**Office of
Environment
& Heritage**

DOC15/506144
SSD 7228

The Sydney Zoo, Western Sydney Parklands, Environmental Impact Statement (SSD 7228)

Attachment 1: Office of Environment and Heritage comments on The Sydney Zoo, Western Sydney Parklands, Environmental Impact Statement (SSD 7228)

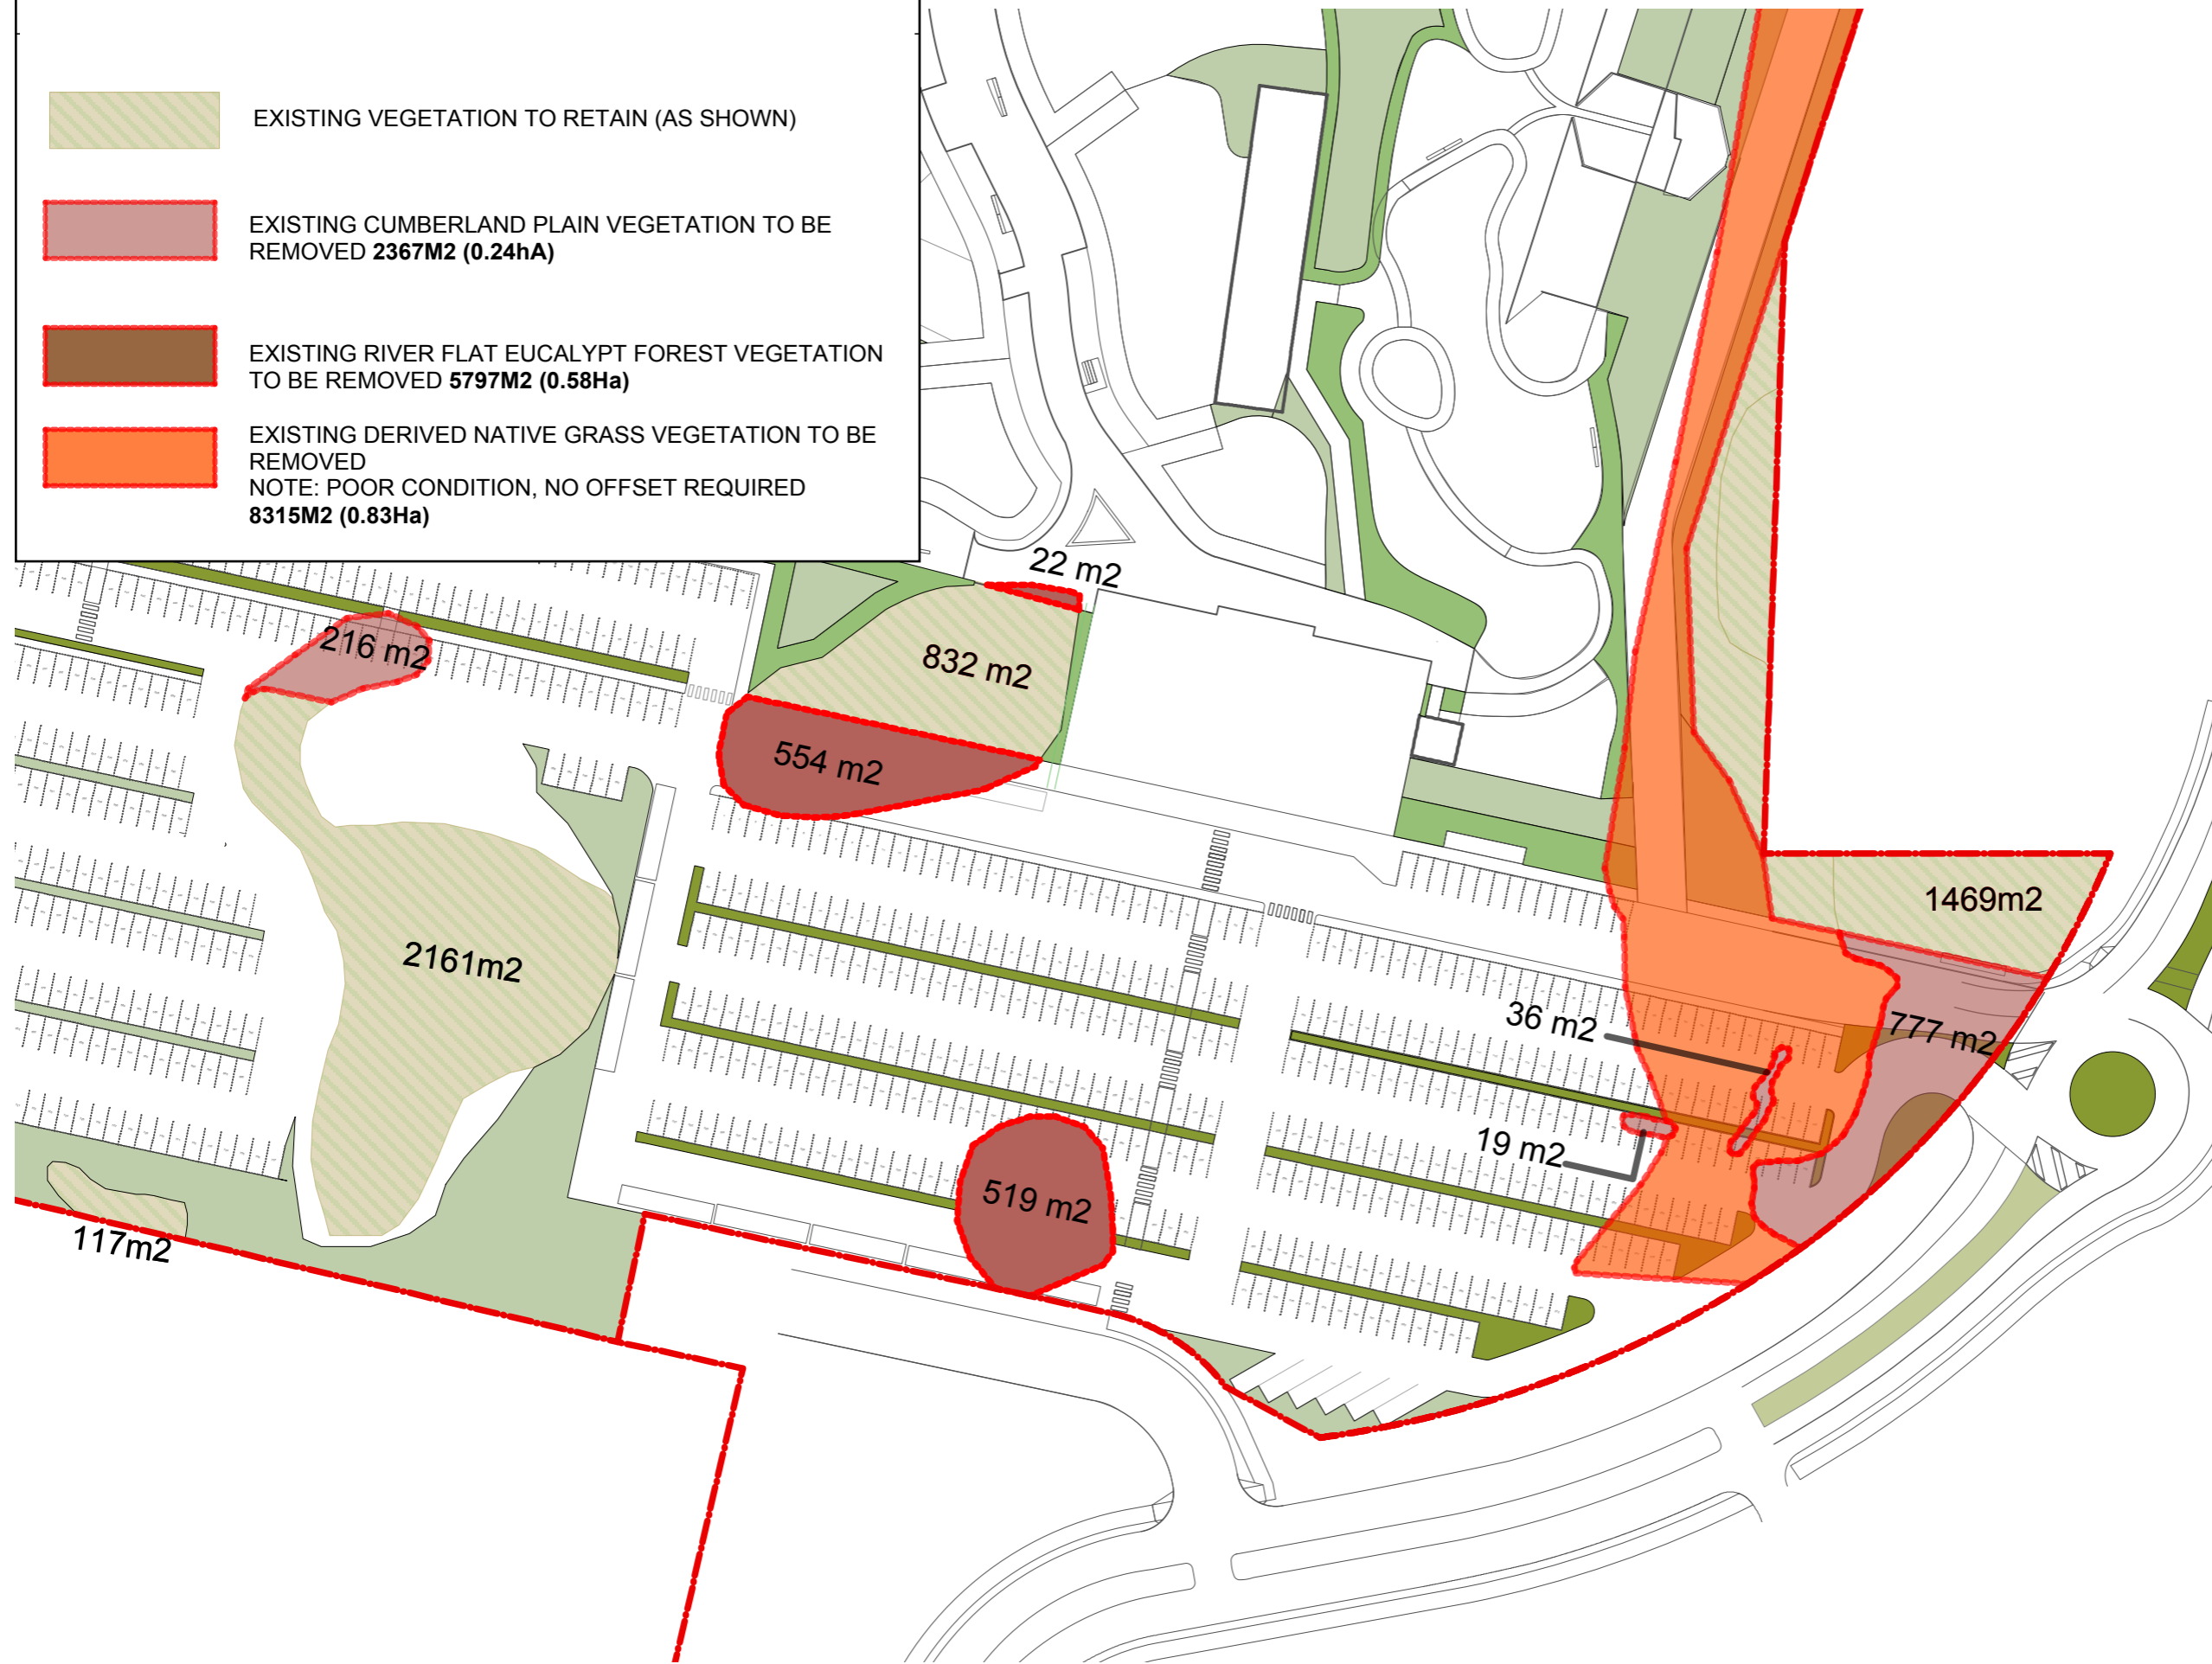
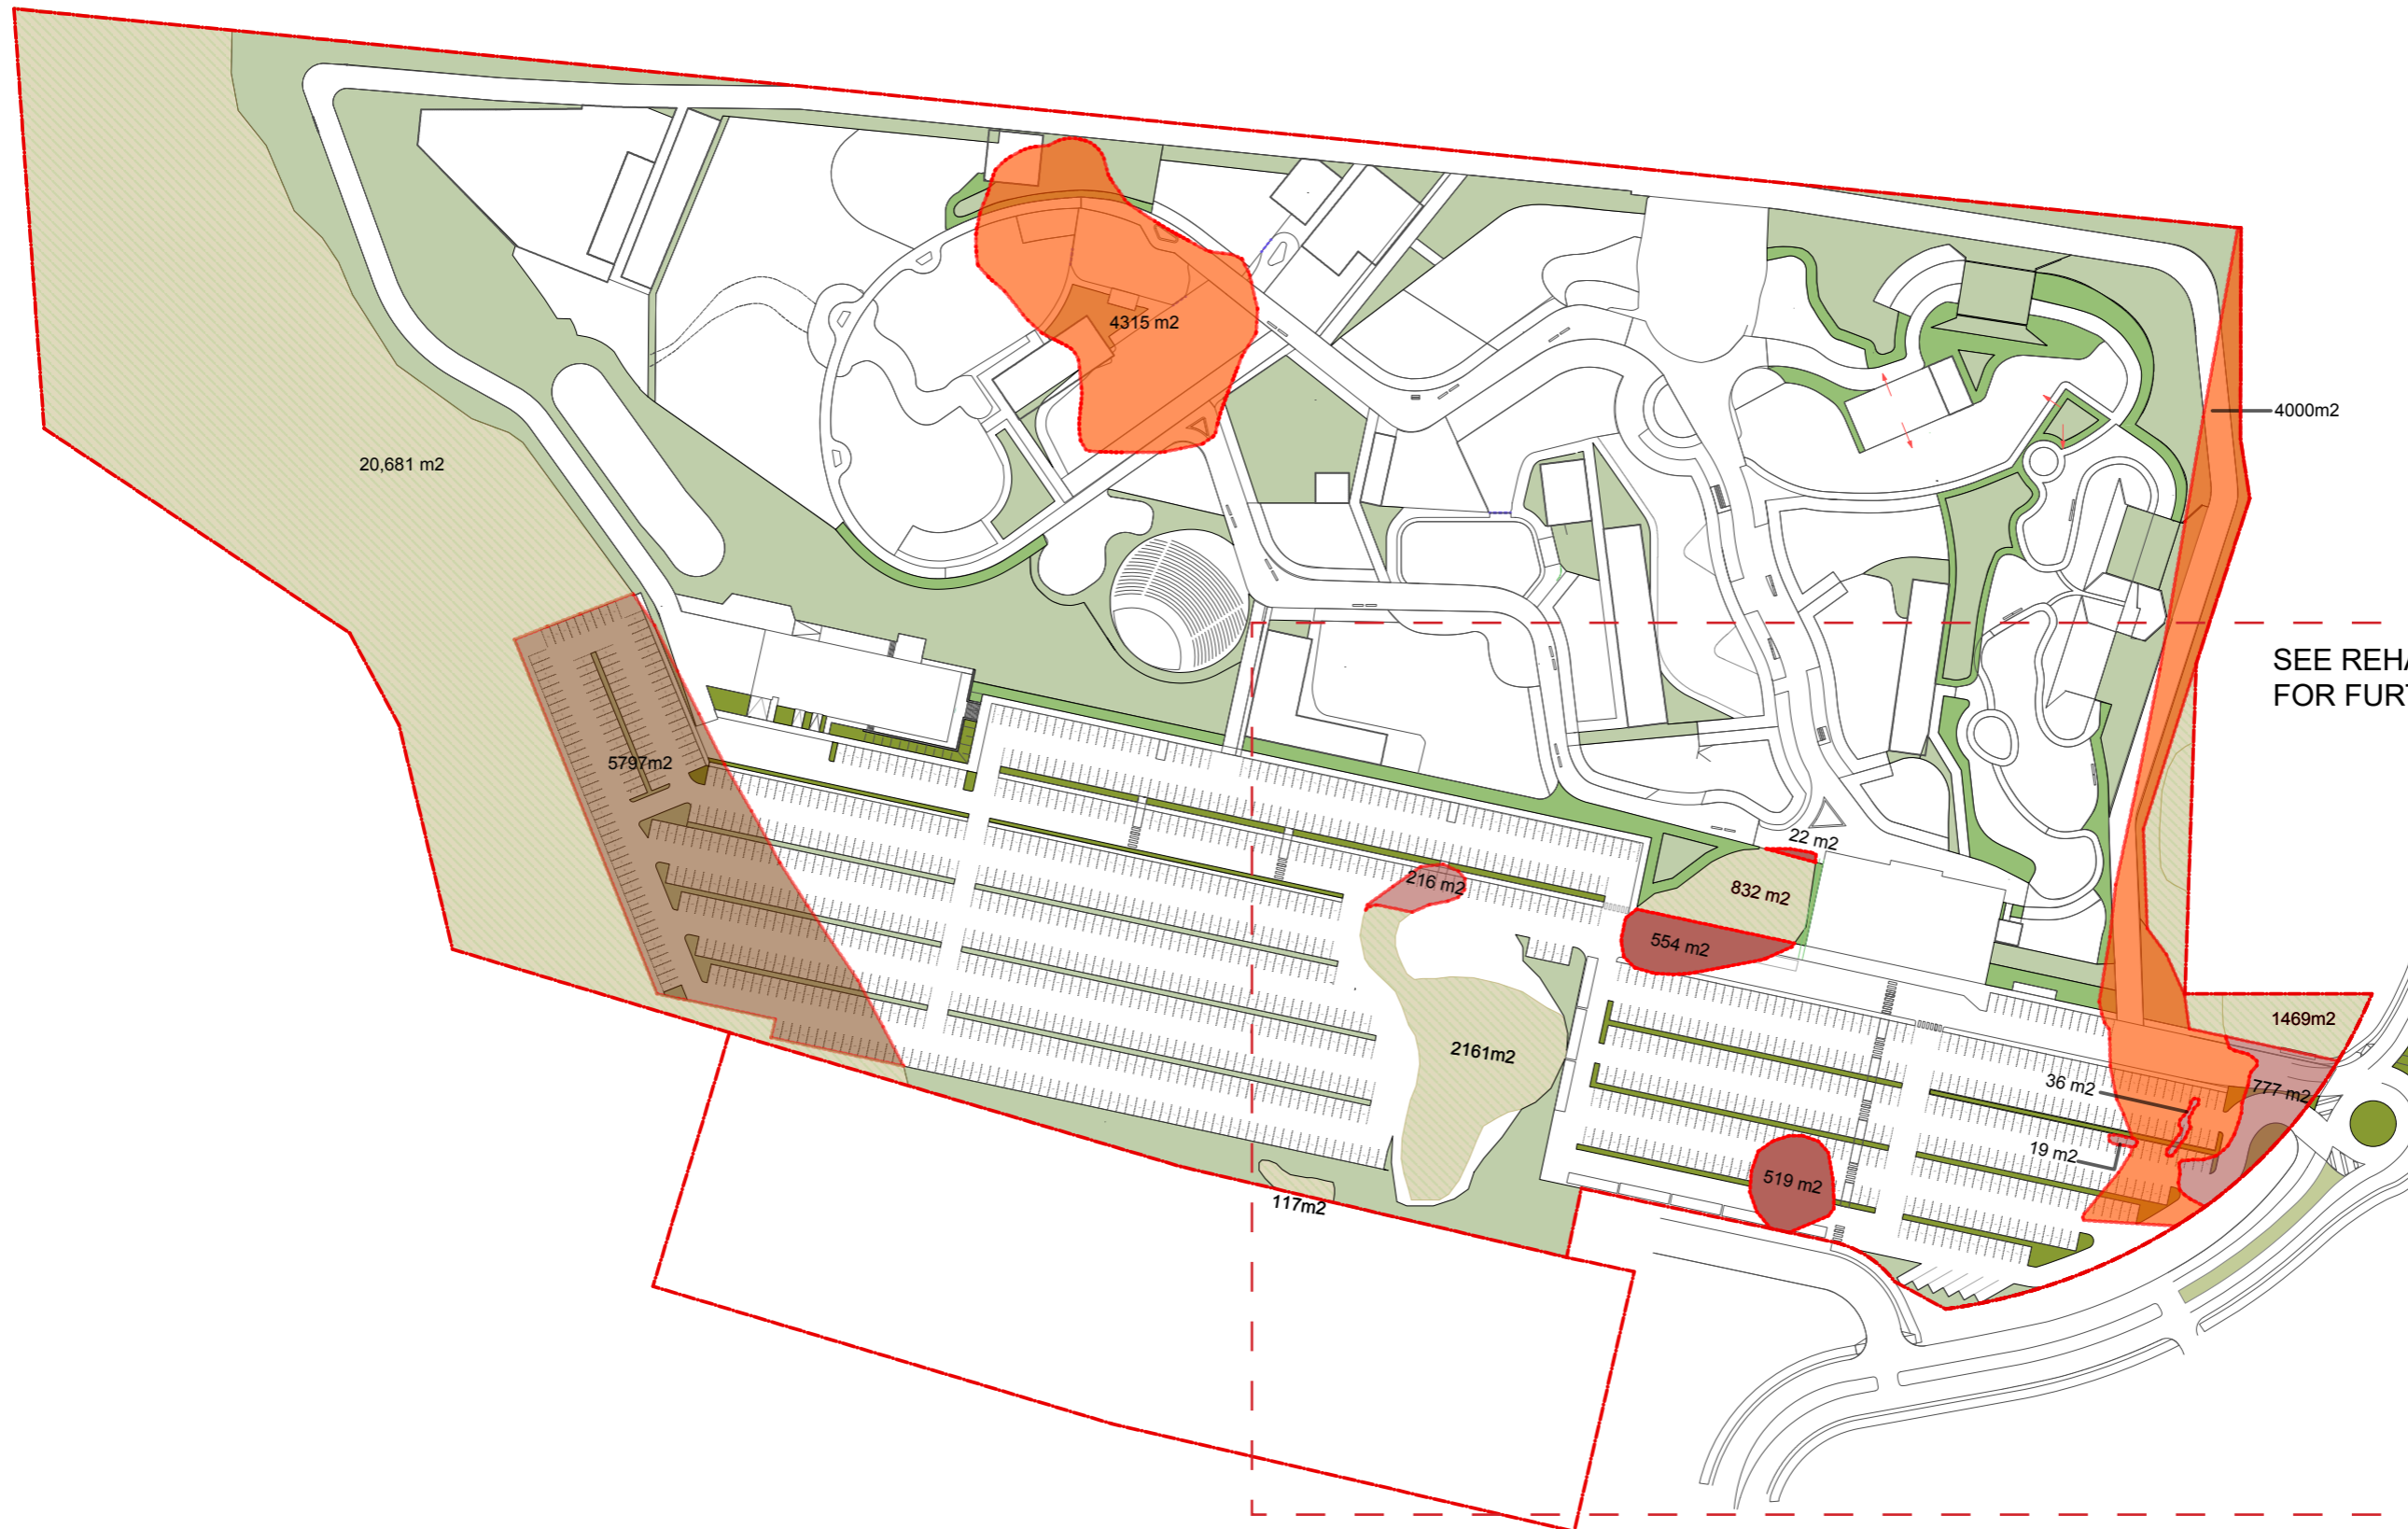
- Landscape Masterplan Part 15 (DWG L22 Rev A) is not consistent with the GIS shapefile for 'retained' land: the plan shows 'asphalt car park' over the northern part of the largest 'retained' patch of CPW. However, part of this area is also mapped as 'exotic'; see above. Please clarify the extent of land to be 'retained'.
